Date: 9 February 2022
Project Reference: 12954

RE: **New Liverpool Public School Development
Finished Floor Levels**

Drawing Title
SITE PLAN - PROPOSED

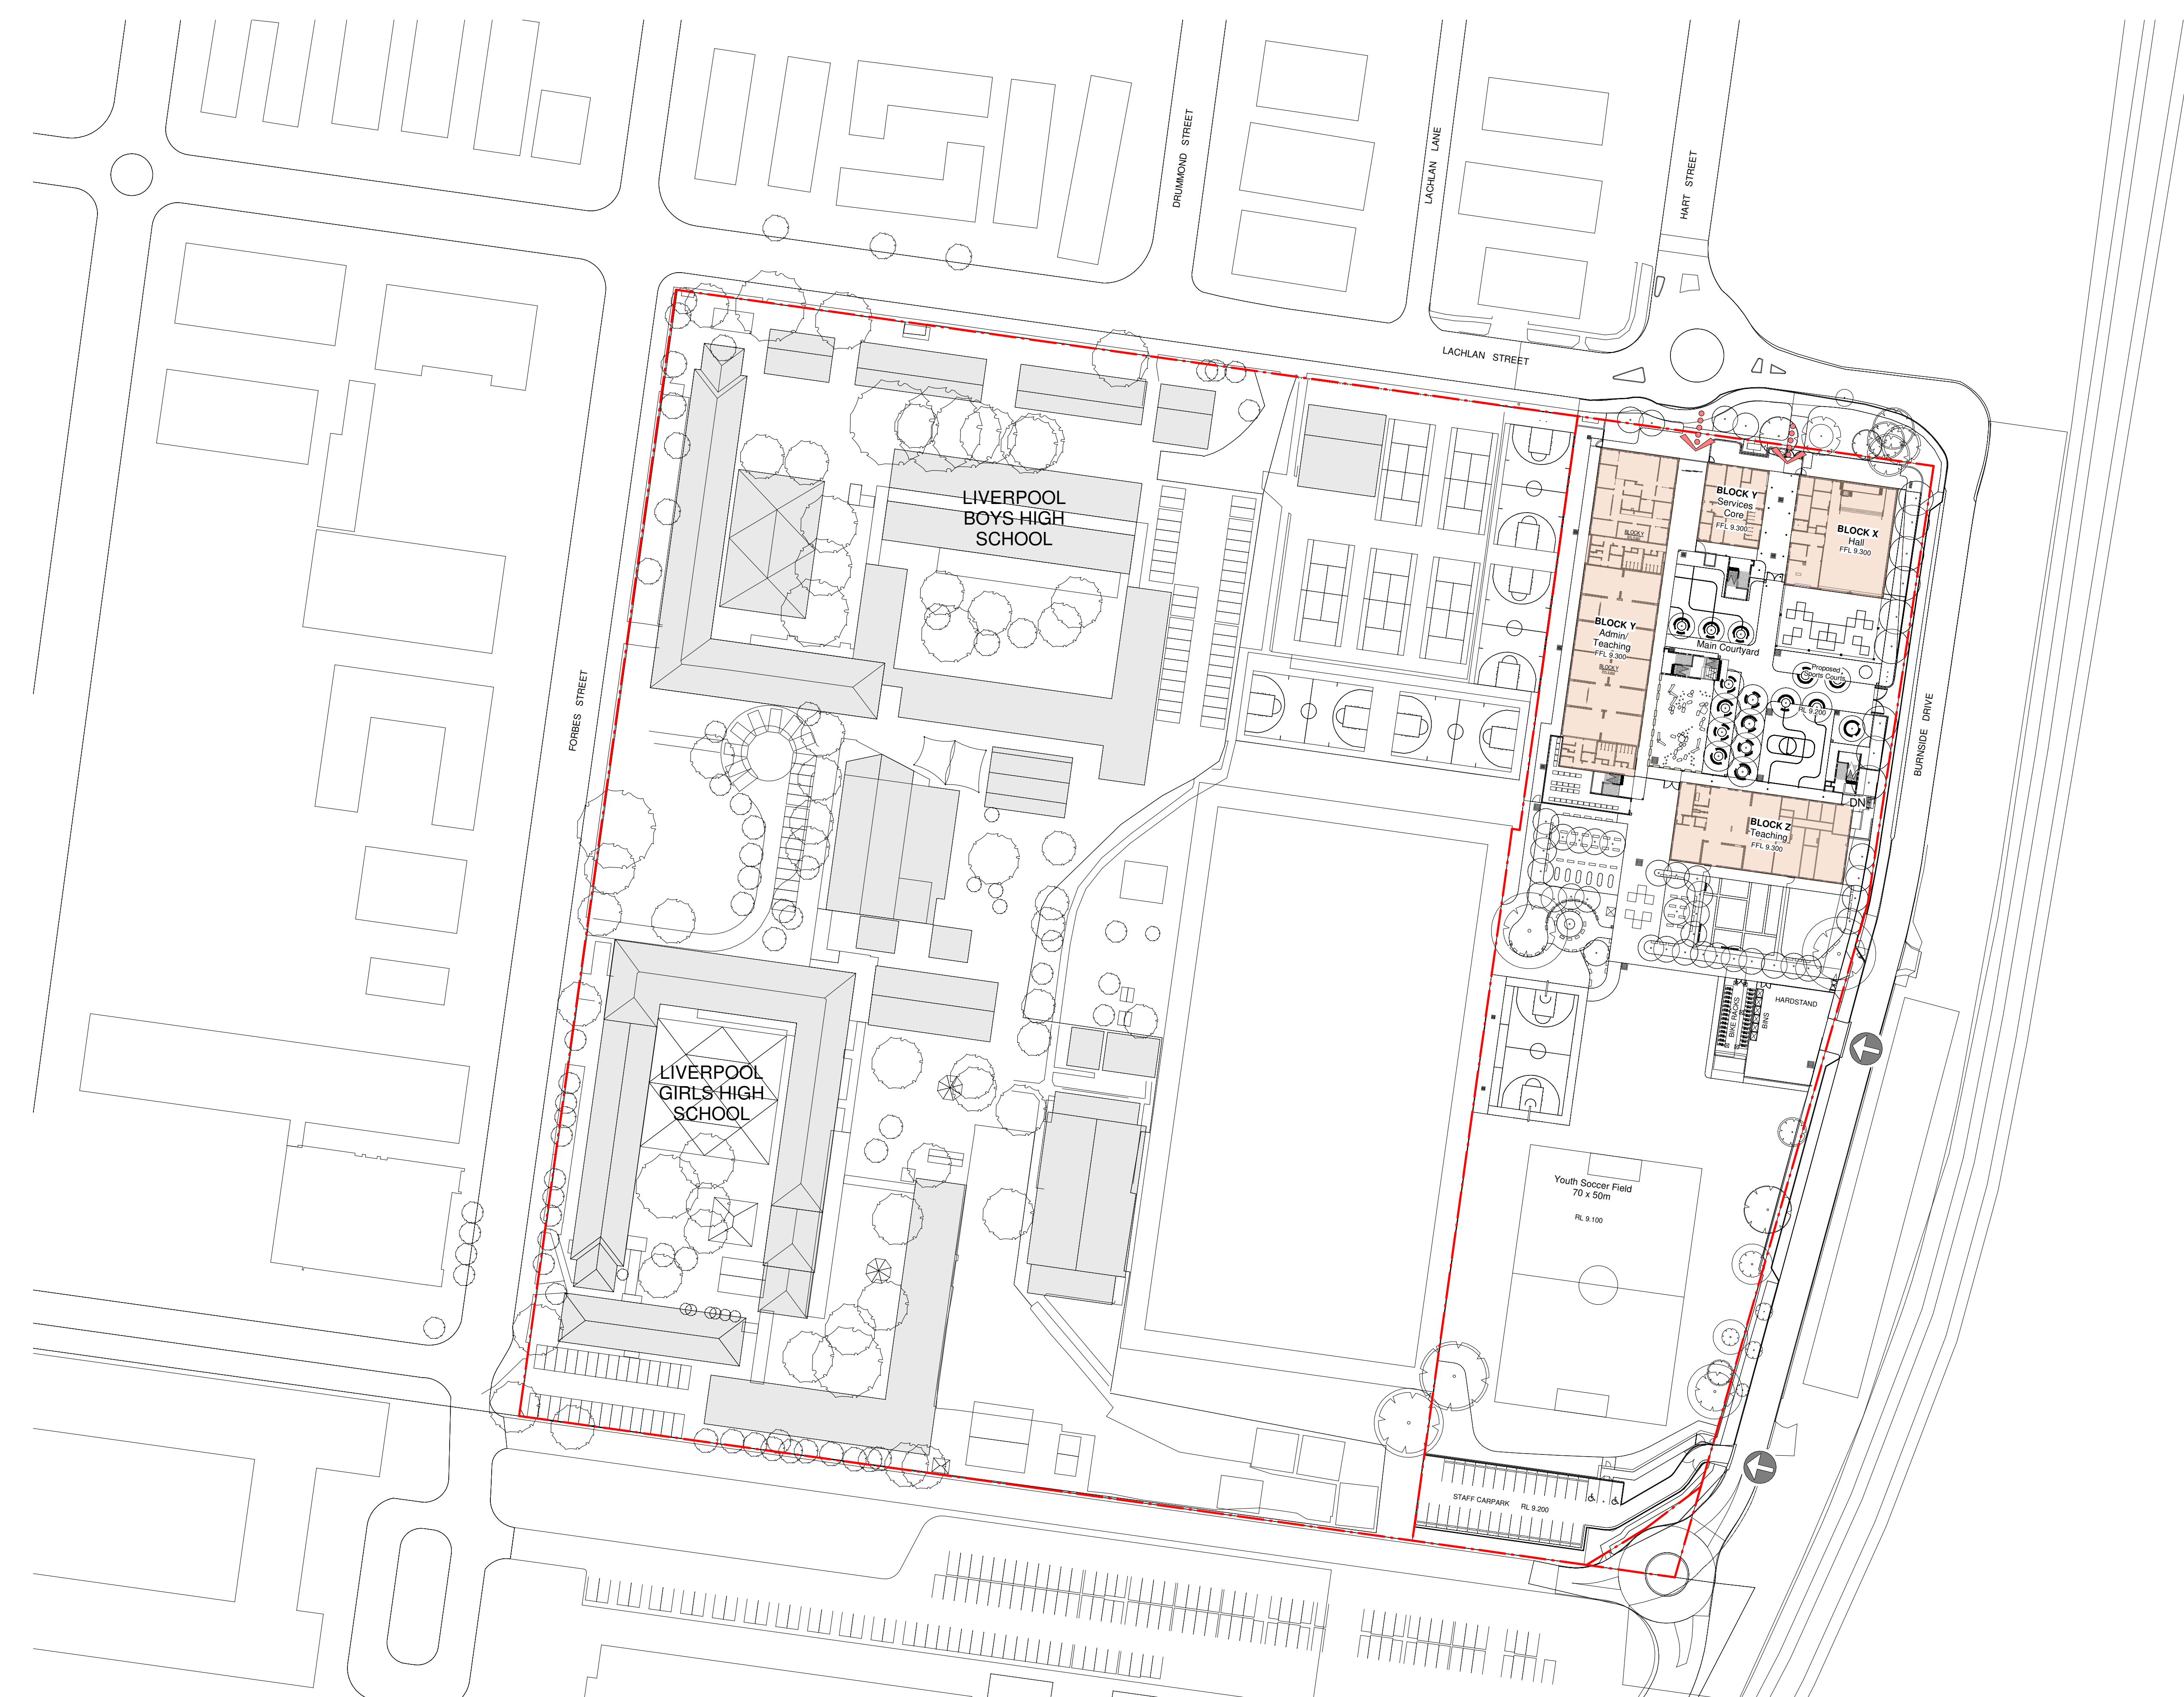
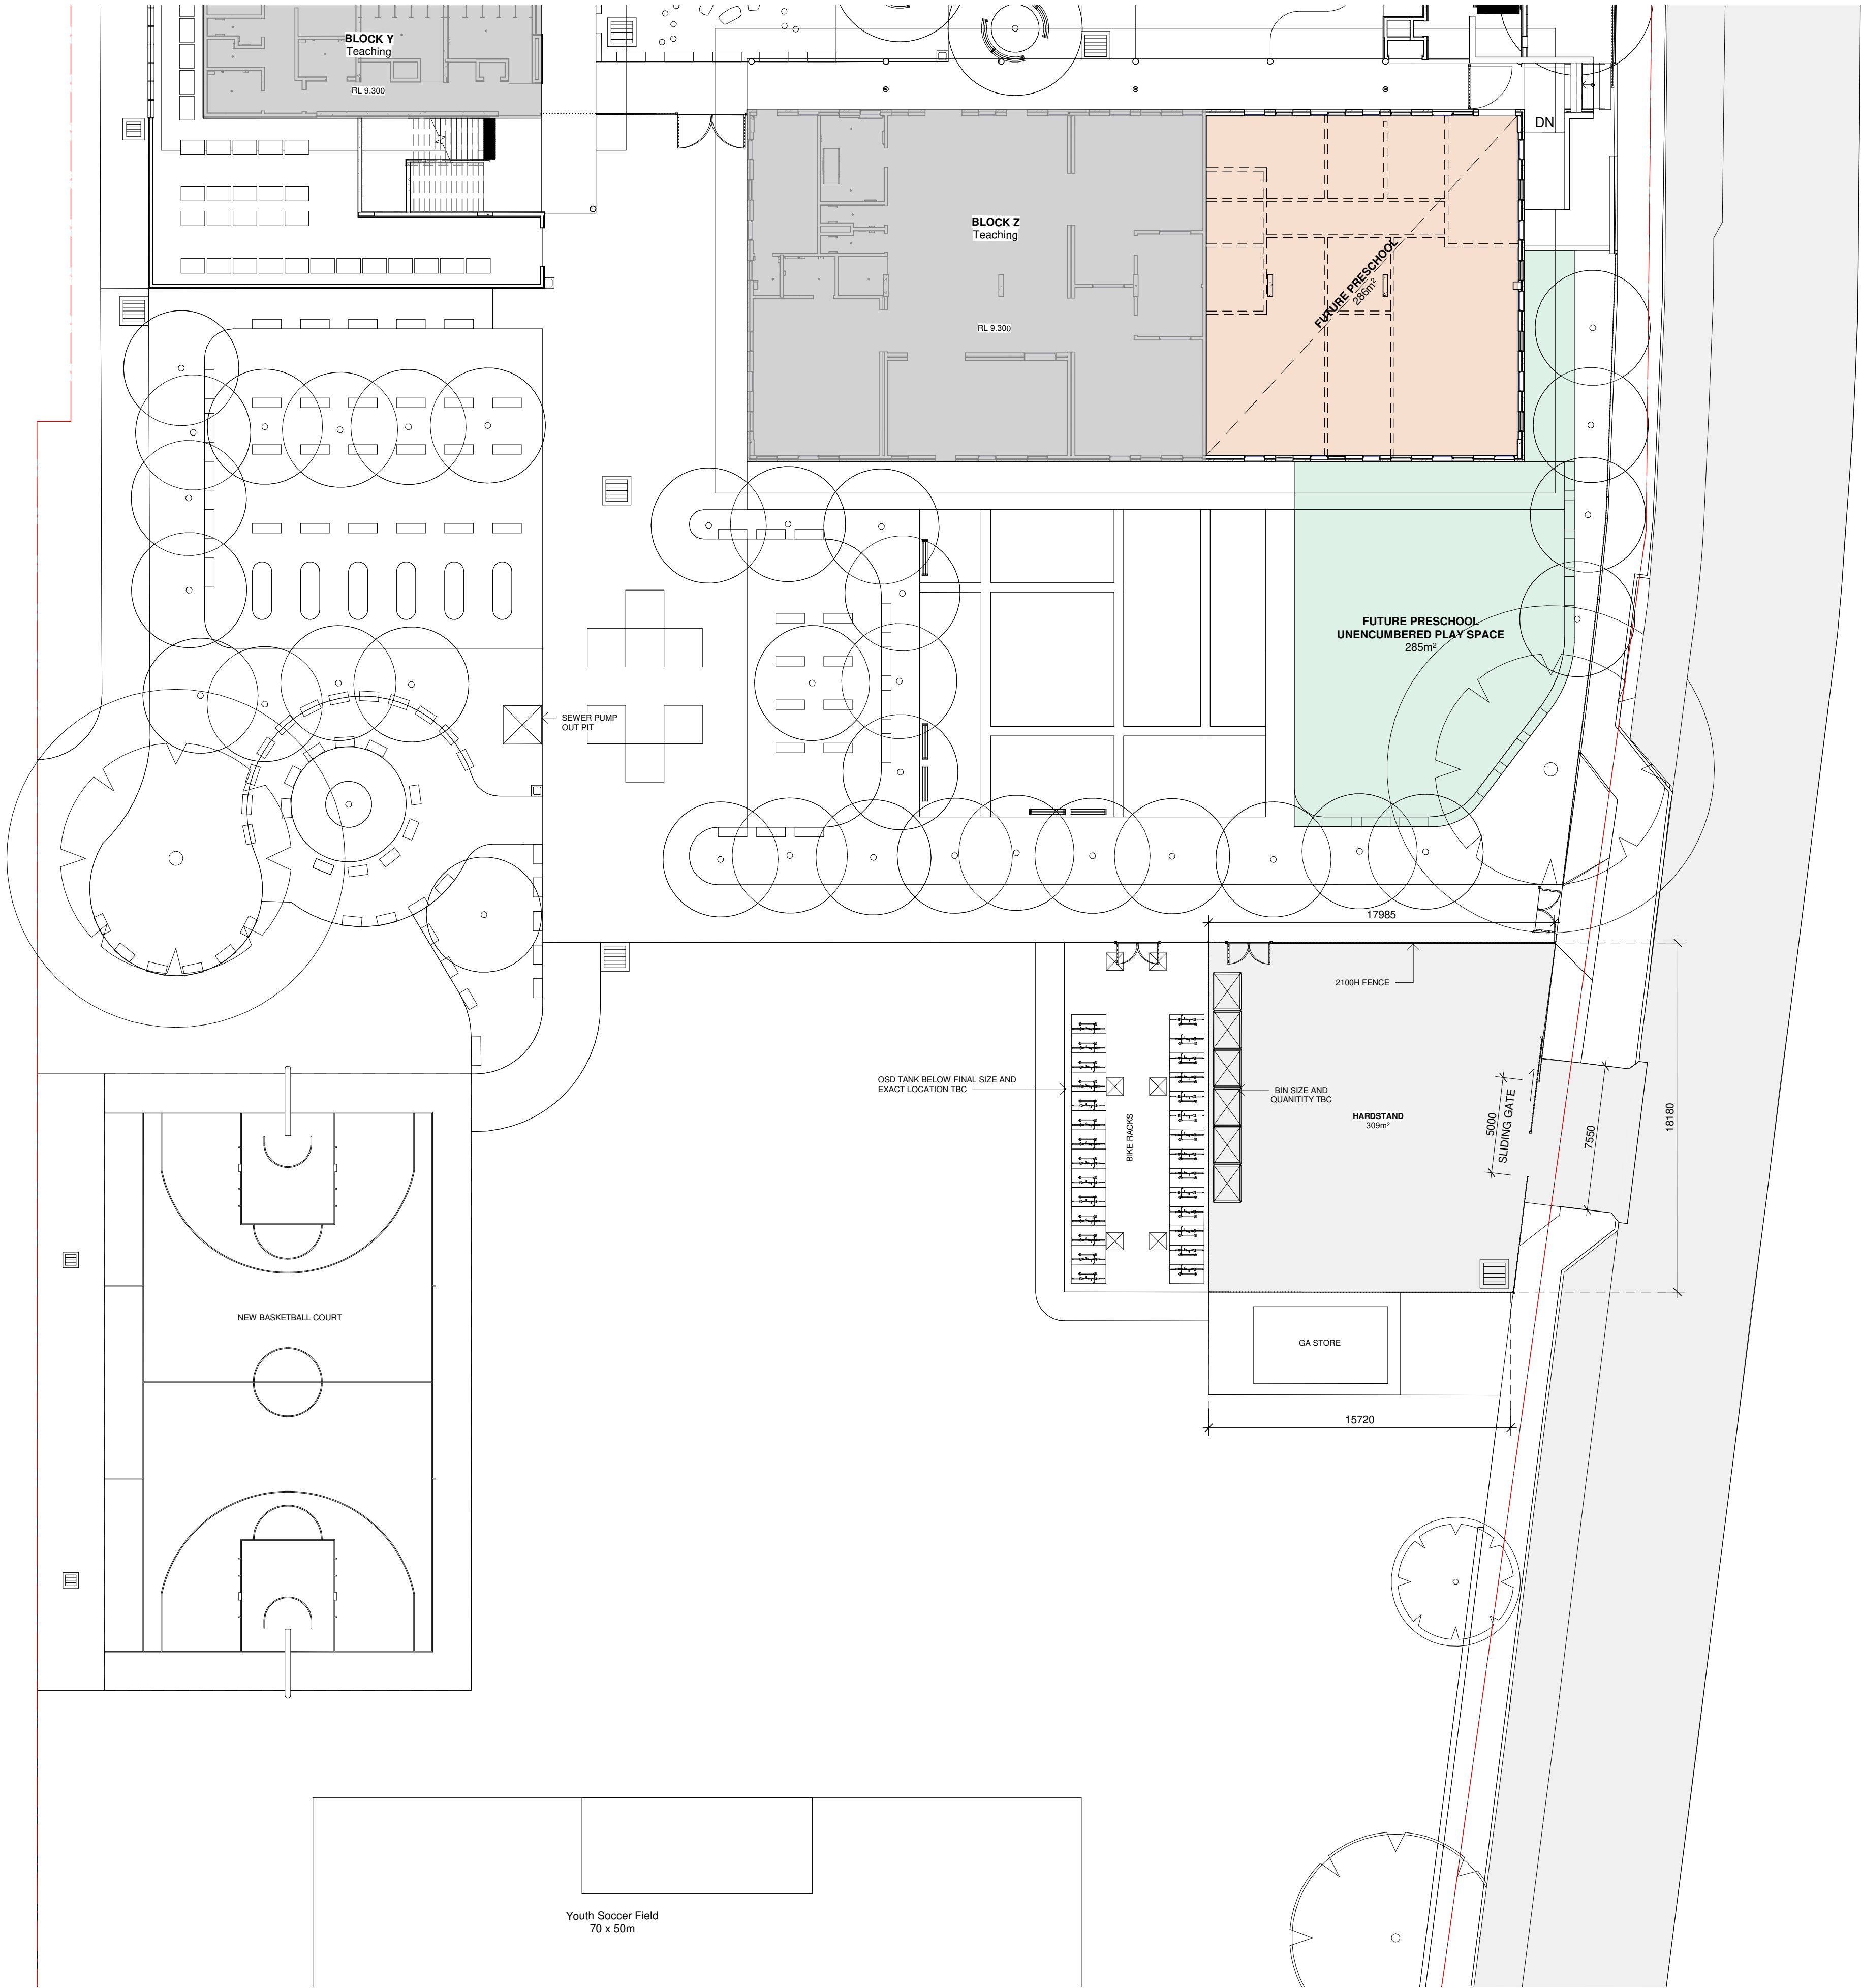
Setting the Finished Floor Level (FFL) at mainstream (Georges River) PMF level at 10.80m AHD in accordance with the Council DCP has the following complications:

- The existing ground level around the northeast corner of the site is RL8.80, which is approximately 2m lower than the estimated mainstream PMF level. Appropriate DDA compliant access between the proposed ground floor to the external ground levels would be difficult to achieve.
- Ramps and stairs would need to be provided. Achieving the Disability Discrimination Act (DDA) compliance would require approximately 45m of ramping into and out of the buildings.
- Significant earthworks would be required to fill the site up to the building pad at RL10.80.

Based on site survey, available flood information and our assessment of the risk, it is recommended to set the FFL at **RL9.30**, for the following reasons:

- The FFL at **RL9.30** would be no lower than the 1 in 100 years ARI flood level plus 500mm freeboard. The estimated 1 in 100 years ARI flood level from the Georges River Flooding is approximated at 8.8m AHD, which results in a minimum FFL at **RL9.30**.
- The PMF level from the Liverpool CBD Overland Flow Flooding is approximated as **9.30m** AHD, setting the FFL at **RL9.30** can protect the new development from the PMF of the overland flooding of the CBD catchment.
- The proposed development is mostly concentrated in the northern portion of site which has existing ground levels between RL8.80 to RL9.20. Construction of ramps and stairs would not be necessary if the FFL is set at **RL9.30**. Access, DDA compliance, would be achievable without major earthworks.
